## 1 Joy Place (CBL #045 E049; ID#2017-128) comments

This email outlines some concerns around the plan for the building being constructed at 1 Joy Place (CBL #045 E049; ID#2017-128).

LANDSCAPE PLAN

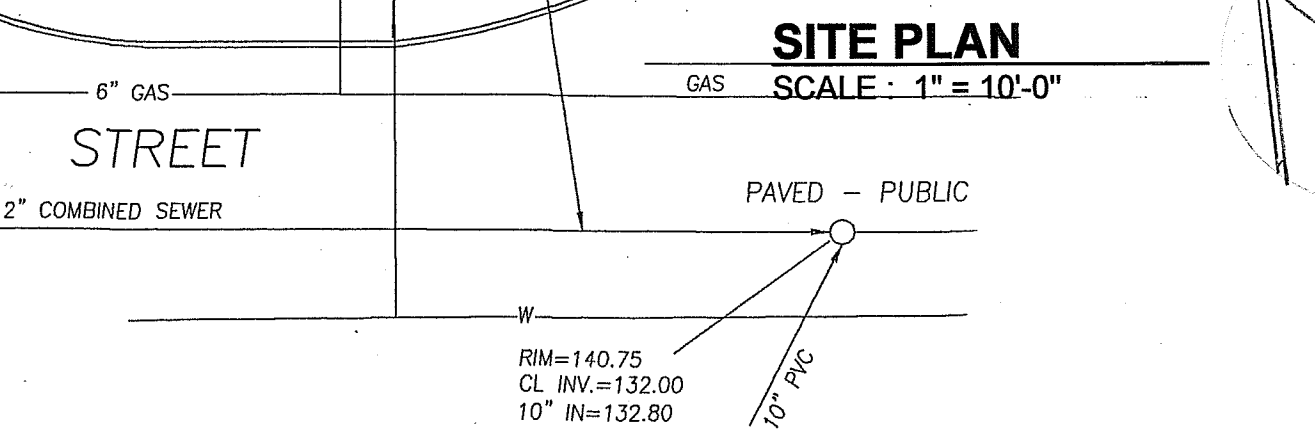
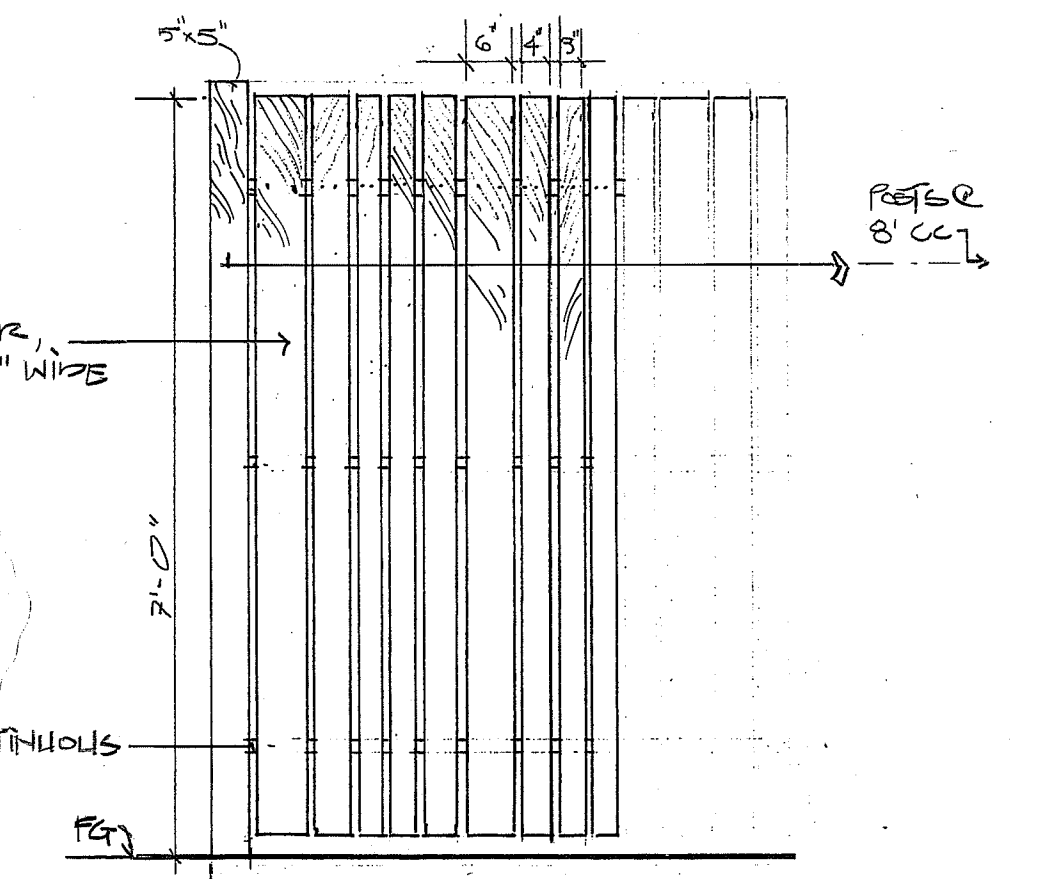
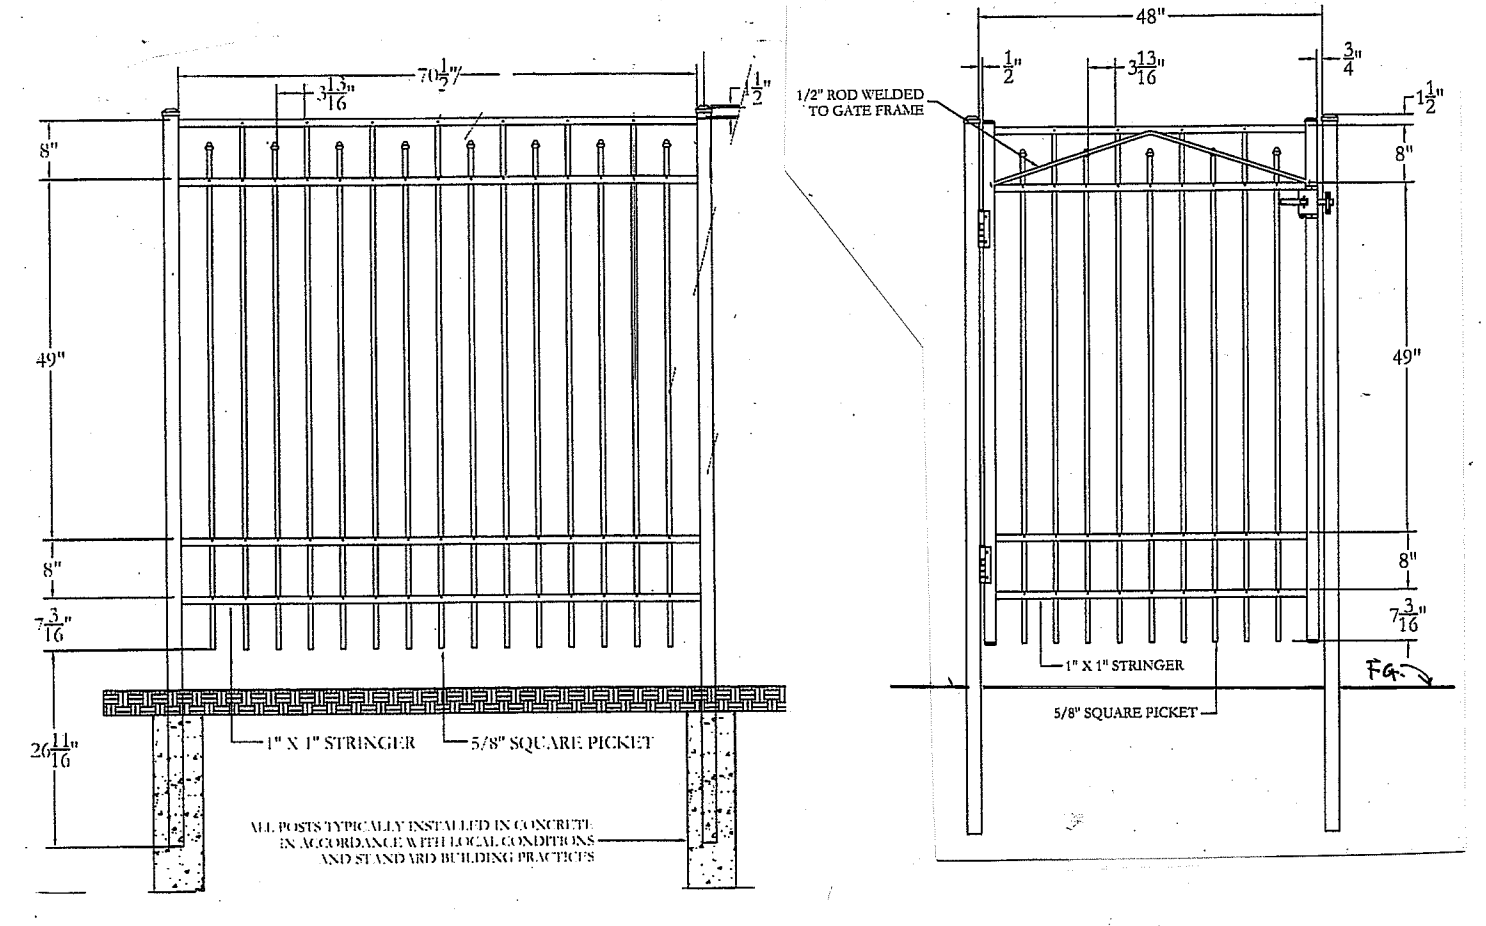
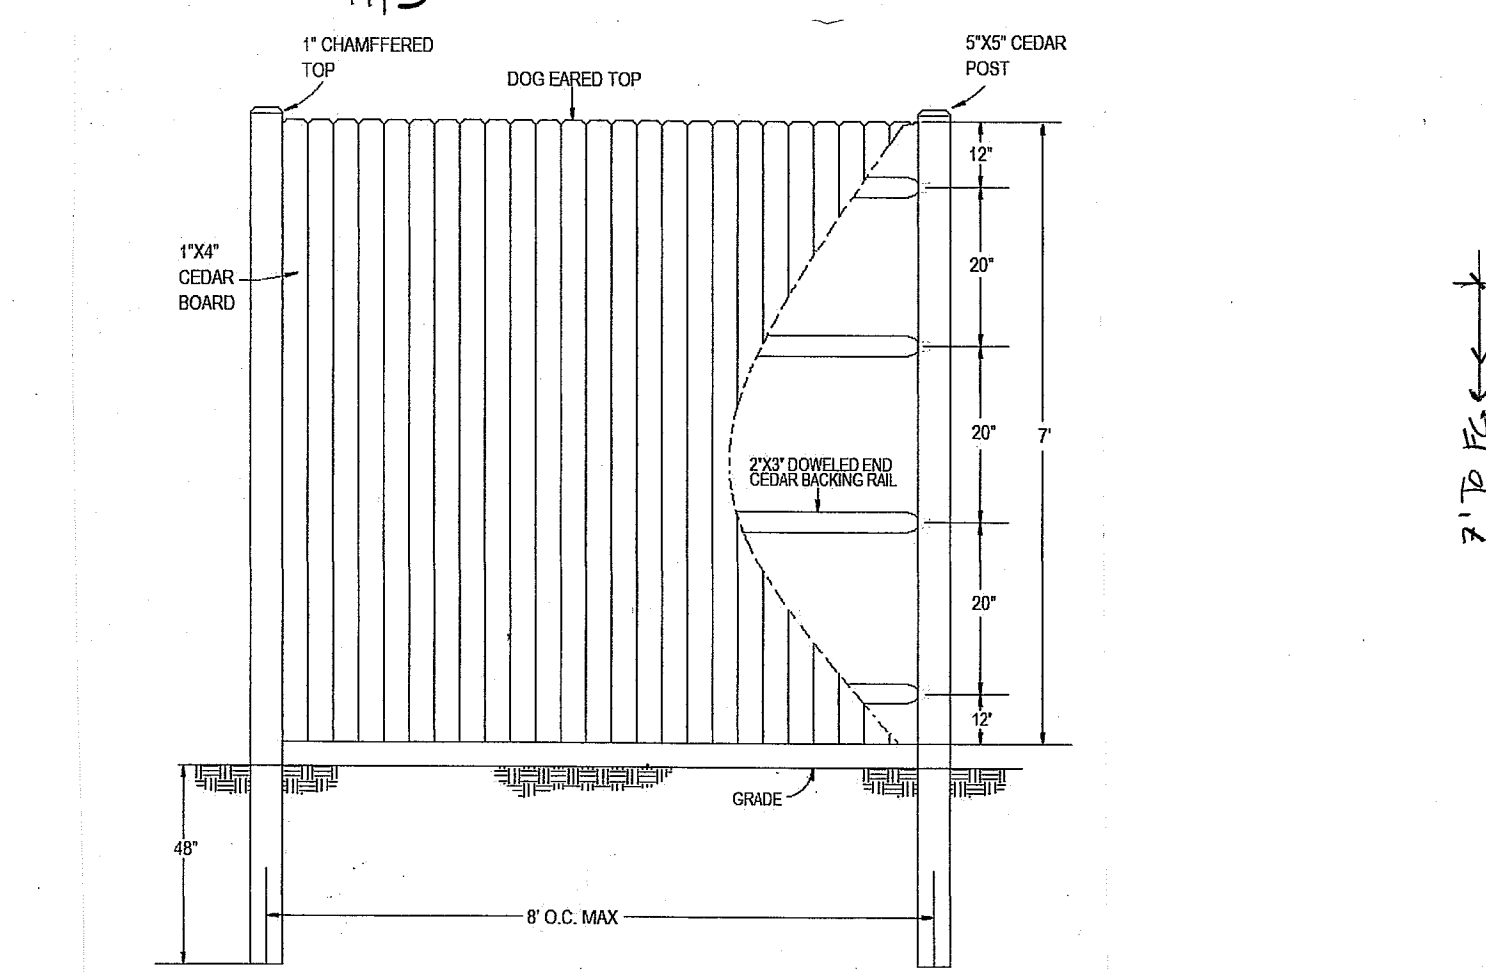
Looking at the submitted plan, it is not clear that the passageway remains sufficiently open. There wasn't a scale on the landscaping plan, so I couldn't measure it to confirm the width. I know it is tight with 1 Joy Place structure being built right up to the edge of right of way.

I also could not tell if the low-growing vinca is actually growing in a raised bed that would impinge on the travel lane.

We ask that the paving and landscaping keep the right of way a clear 12' wide, allowing for vehicles, without running into/over planting beds.

We also have some notes on the fence that is being build to separate the passageway and Joy Place building from our back yard.

- Use a fence on our property line that is **7' or taller** and that has **no gaps between fence boards** (to maintain visual privacy between the passage between our buildings and our back yard).
- Use **solid material (wood) for fence gate** material, also for privacy.
- **Relocate gate 3-6 feet from the corner where it is located** on the plan (existing plantings on our property are in the way if it stays the corner location and would obstruct passage)
- Confirm that our deeded right of way is a clear **12' wide** and allows for vehicle passage.
